WEST SUSSEX COUNTY COUNCIL CONSULTATION

TO:	Arun District Council FAO: Michael Eastham
FROM:	Stephen Gee WSCC - Highways Authority
DATE:	15 April 2019
LOCATION:	<u>Boweries Barnham</u> Road Chichester <u>PO20 3RT</u>
SUBJECT:	<u>EG/22/19/OUT</u> Outline application with some matters reserved for the erection of 28 No. dwellings, access, landscaping & associated works (resubmission following EG/42/18/OUT).
DATE OF SITE VISIT:	3/8/18
RECOMMENDATION:	More Information
<u>S106</u> CONTRIBUTION TOTAL:	£ See below for breakdown.

FIGURE 1.4

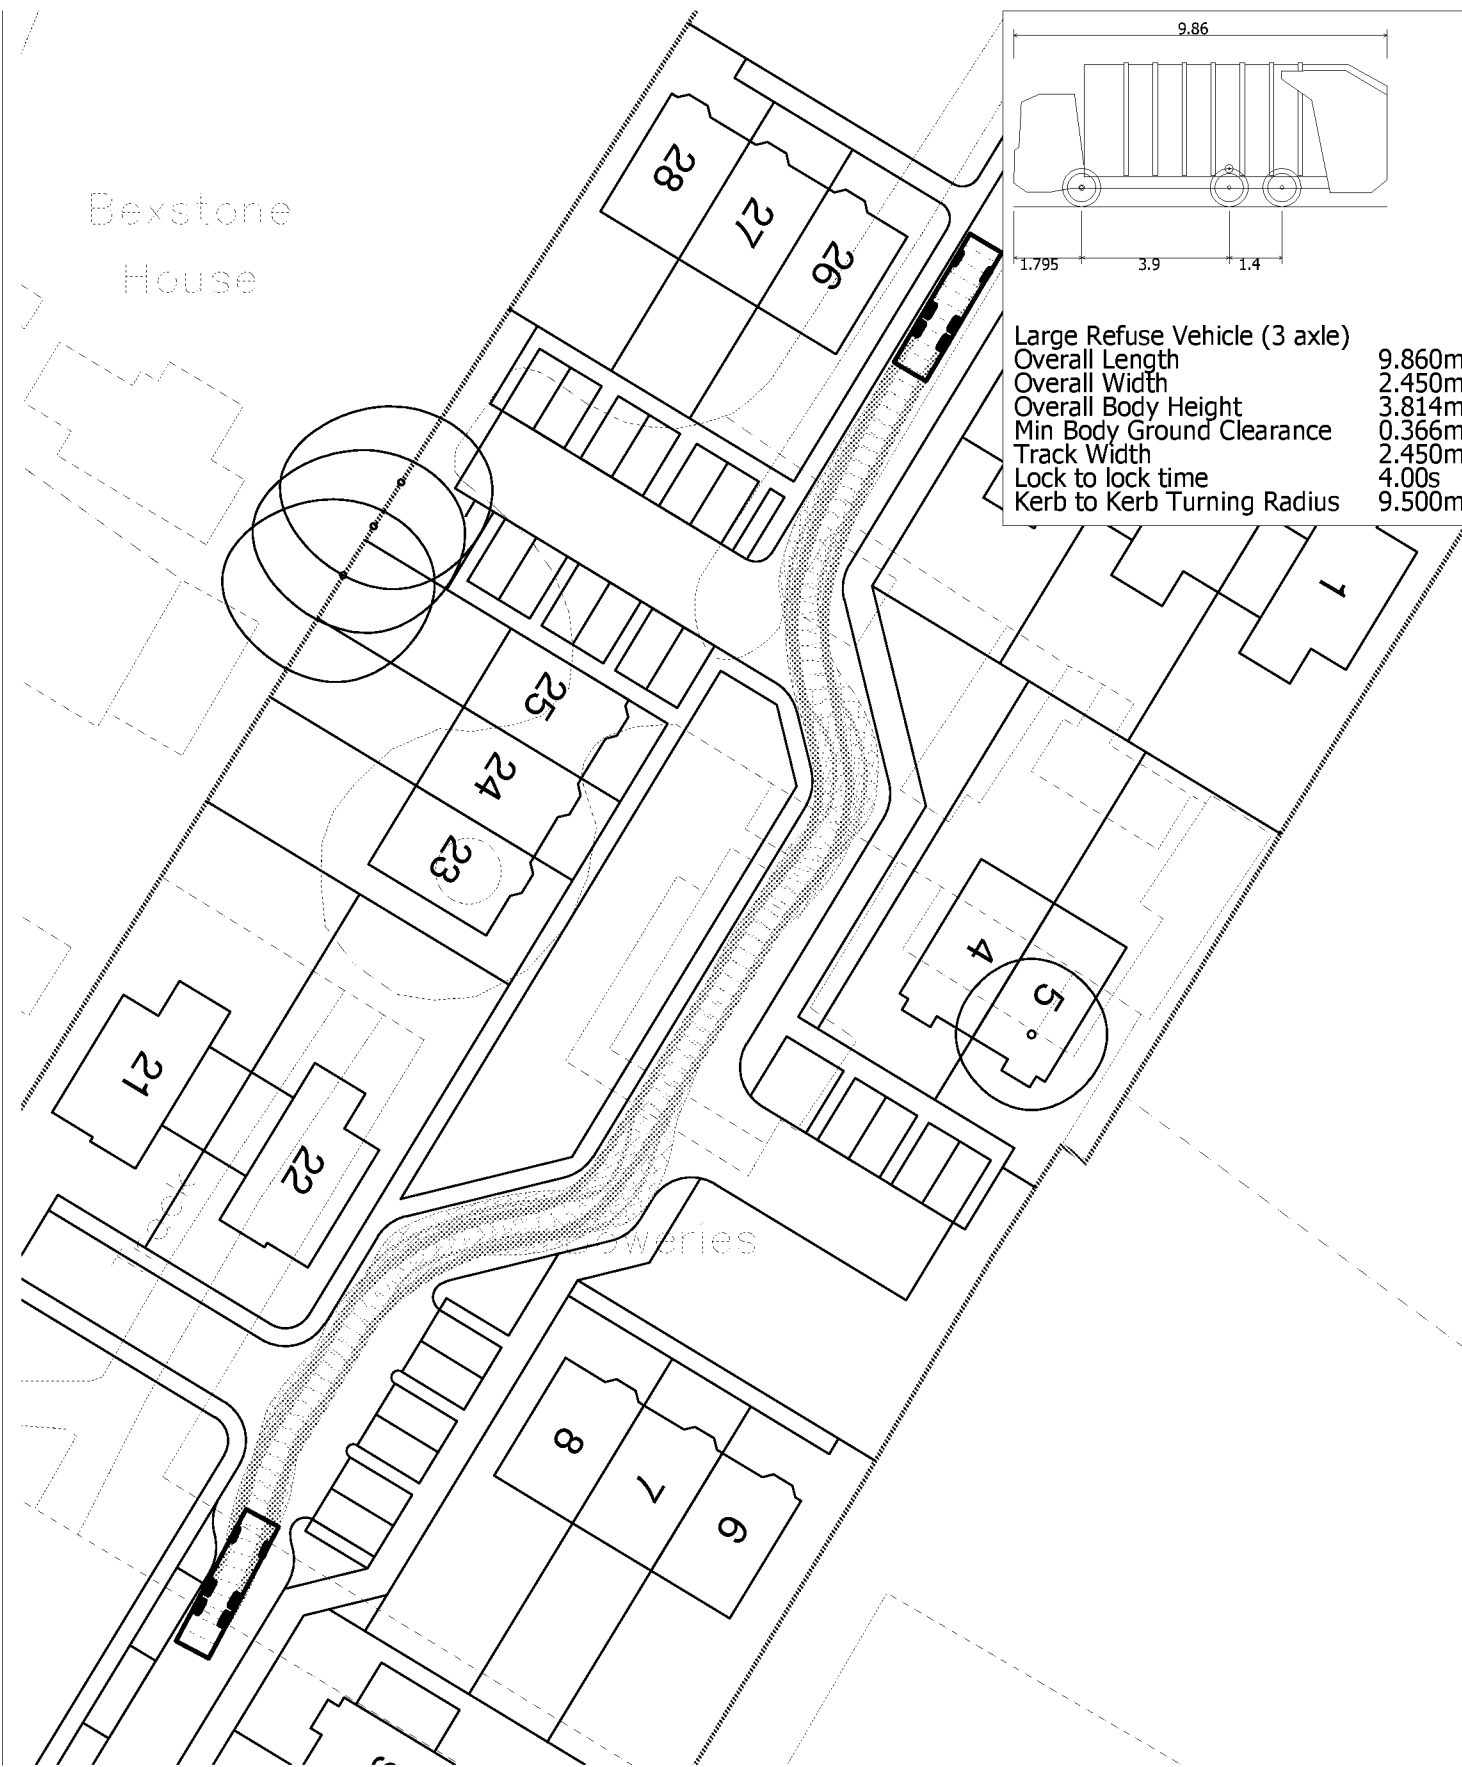
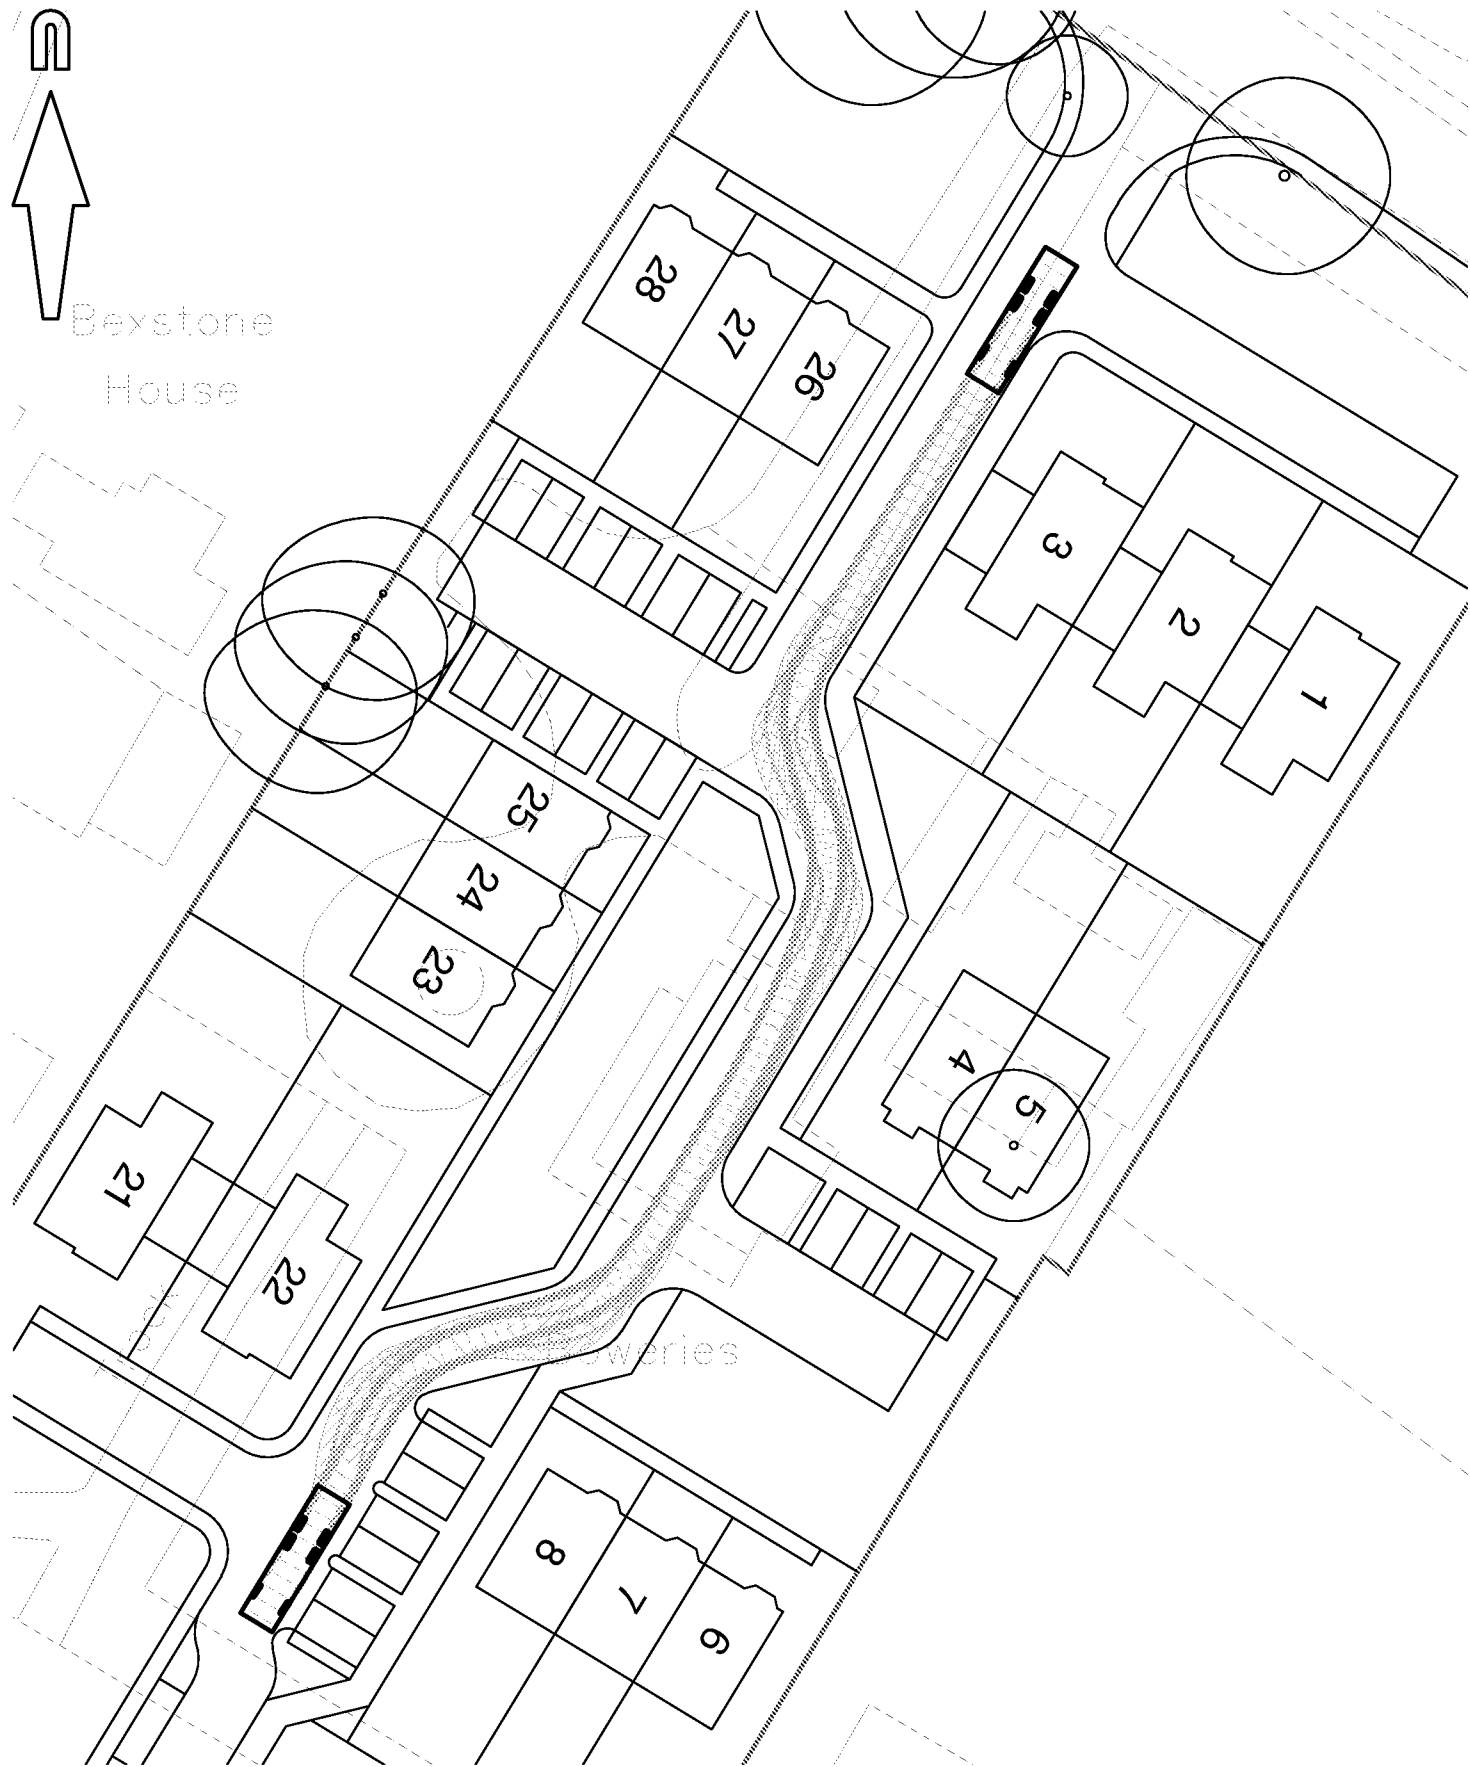
Vehicle tracking has been provided and shows the site access can accommodate a large refuse vehicle however no vehicle tracking has been provided for a southern turning head.

Whilst the application is outline only further information is required to establish if the site can accommodate the provision of a satisfactory turning head enabling refuse vehicles to enter and exit in a forward gear and accommodate the levels of parking as set out in the WSCC parking demand calculator. The applicant should also confirm acceptance of the strategic infrastructure contribution.
